**Consultation Response from KC,
 Policy**
2022/93731 Woolpack Inn, Whitley Road, Whitley, Dewsbury, WF12 0LZ
Partial demolition and alterations to convert public house to 5 residential units
Date Responded:
Responding Officer: Amy Woodhead
Responding Ref:

This application is seeking planning permission for the partial demolition and alterations to convert a public house to 5 residential units at, Woolpack Inn, Whitley Road, Whitley, Dewsbury, WF12 0LZ. The application site is in the Green Belt, so Green Belt policies in the National Planning Policy Framework (NPPF), and Kirklees Local Plan (KLP) will apply.

BLOCK PLAN - PROPOSED

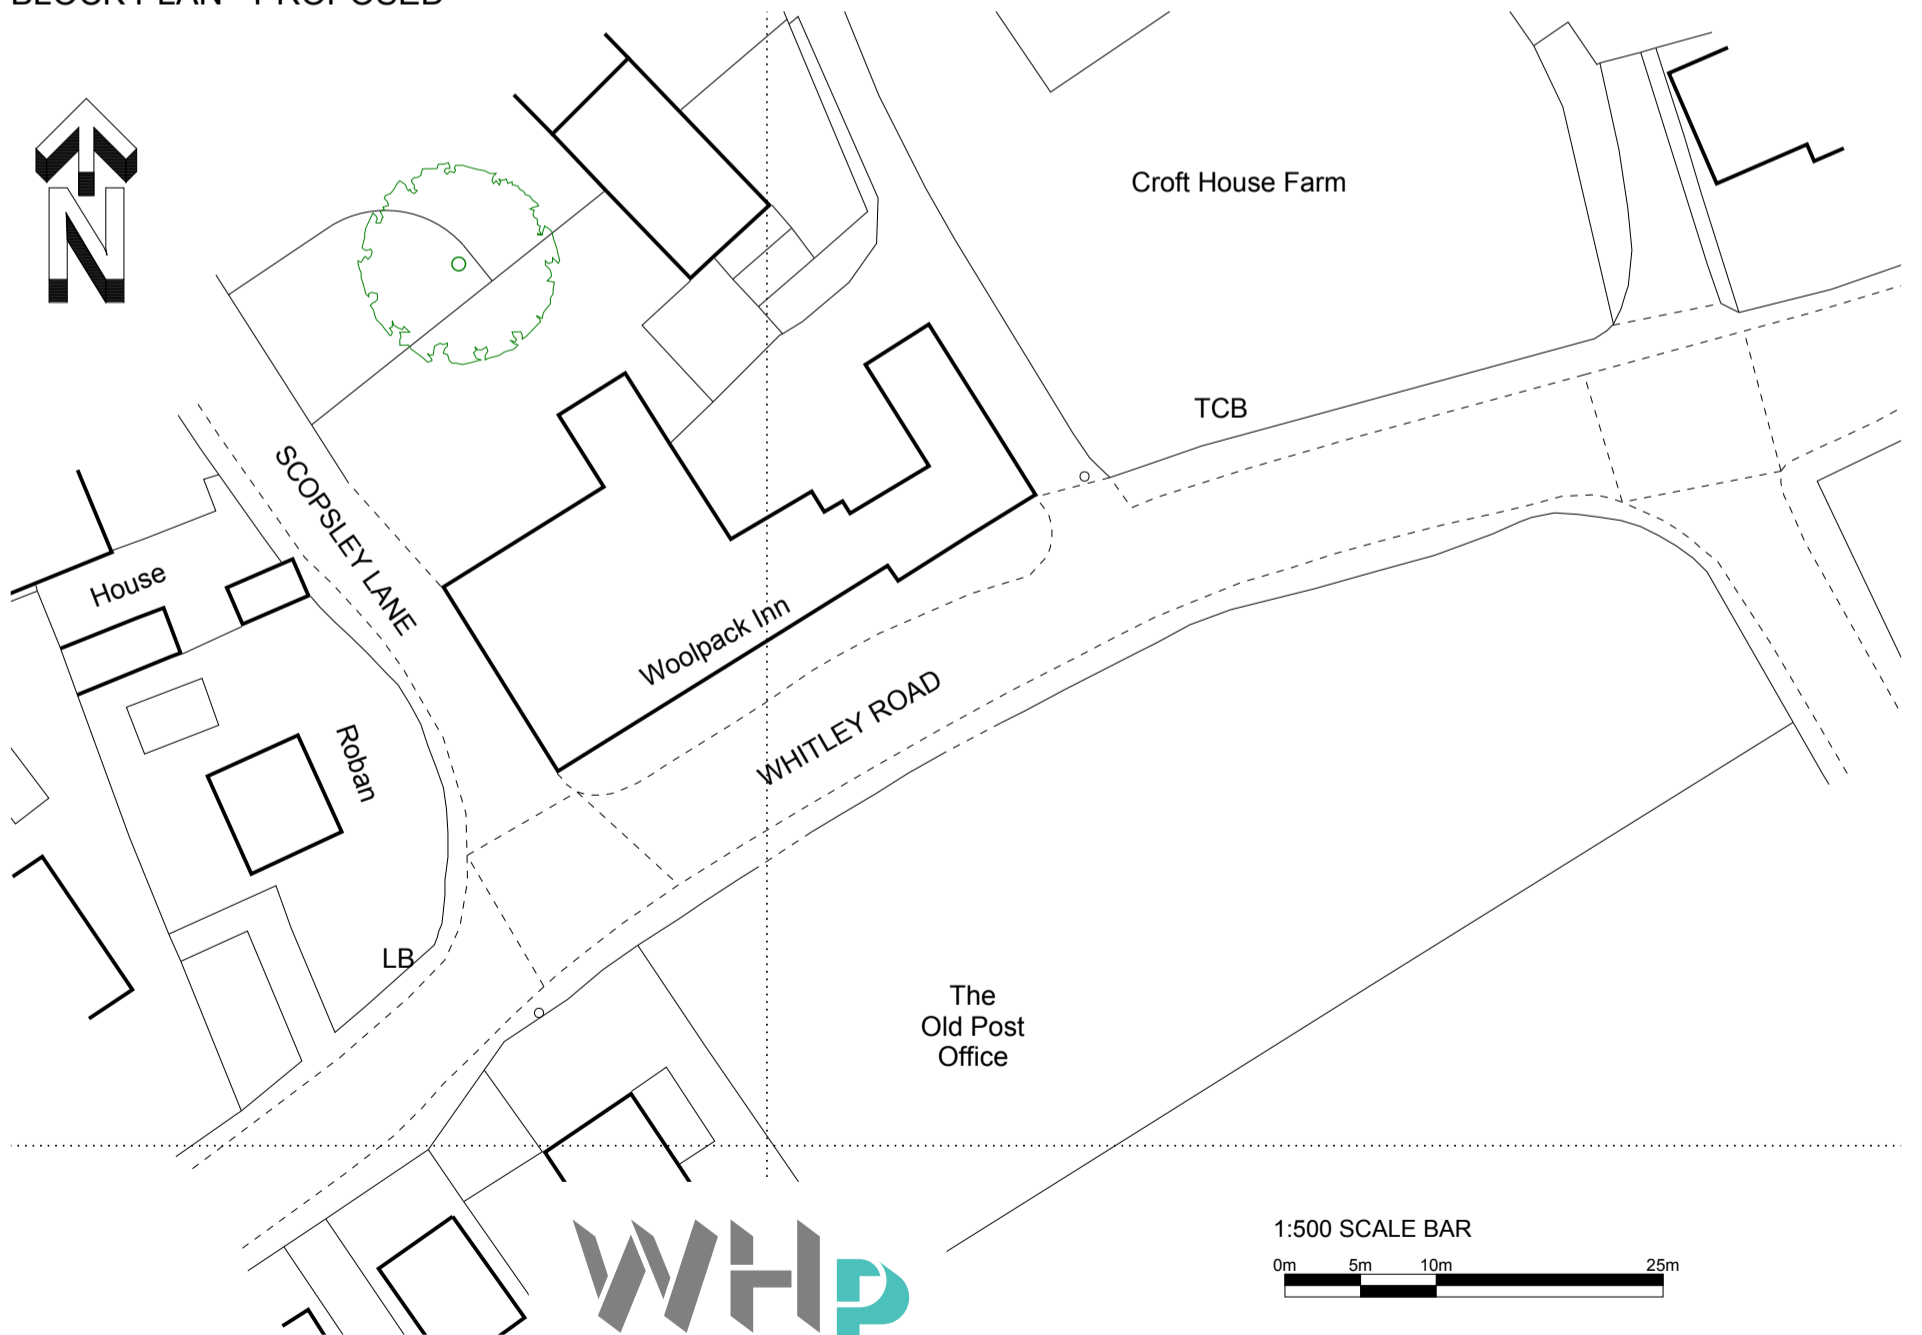
Criterion b of LP60 states that proposals concerning the conversion or re-use of buildings should not introduce incongruous domestic or urban characteristics into the landscape, including through the treatment of outside areas such as means of access and car parking, curtilages and other enclosures and ancillary or curtilage buildings. It is important to note that in this case, the application site is not in the open countryside, it is within the Whitley Lower settlement – and the curtilage of the Woolpack Inn currently comprises the pub, a car park and a small section of amenity space. The plans illustrate that a section of the existing structure to the rear is to be demolished as part of this scheme, to allow for a greater provision of green space and additional car-parking. Timber panel fencing, of a 'domestic' nature, will also be introduced to the rear of the structure, to separate the plot boundaries of the residential units. Due to the position of the Woolpack being within a settlement and **not** open countryside, development of this type would not constitute urban encroachment, therefore does not conflict with the purpose of including land within the Green Belt. There will also be no material difference in the level of openness of the Green Belt through implementing the proposed scheme, as the proposed arrangement and operation of the site will not differ too greatly to how it appears and functions at present. However, dividing the site into individual plots, through positioning timber panel fencing across the space will result in the fragmentation of land. While not material, it would be preferable if alternative arrangements for the private amenity space could be considered.

In addition to this, in terms of criterion (c) of LP60, using timber panel fencing as a boundary treatment in these circumstances may fail to be in keeping with the wider setting. As such, it might be appropriate to consider whether a less 'suburban' boundary treatment would be available to use, that would better suit the context – for example a low wall, or hedging. Another factor to note regarding criterion (c) of policy LP60 is, while it is not clear from the plans, it appears as though the scheme is designed in such a way it will result in the loss of a dwarf wall that currently stands on Scopsley Lane, to separate the Woolpack curtilage from the road frontage. Four parking spaces are proposed to be provided along the road frontage of Scopsley Lane where the dwarf wall currently stands. The low boundary wall is a feature of Scopsley Lane and is characteristic of the area, therefore it would be preferable if the dwarf wall could be retained. Principle 12 of the Housebuilders Design Guide states that parking provision should not dominate street frontages through parking arrangements that places cars at the front of dwellings. Where car parking is accommodated at the side of buildings, as it is in this case, creative design solutions should ensure that car parking can be accommodated to avoid dominating the street scene.
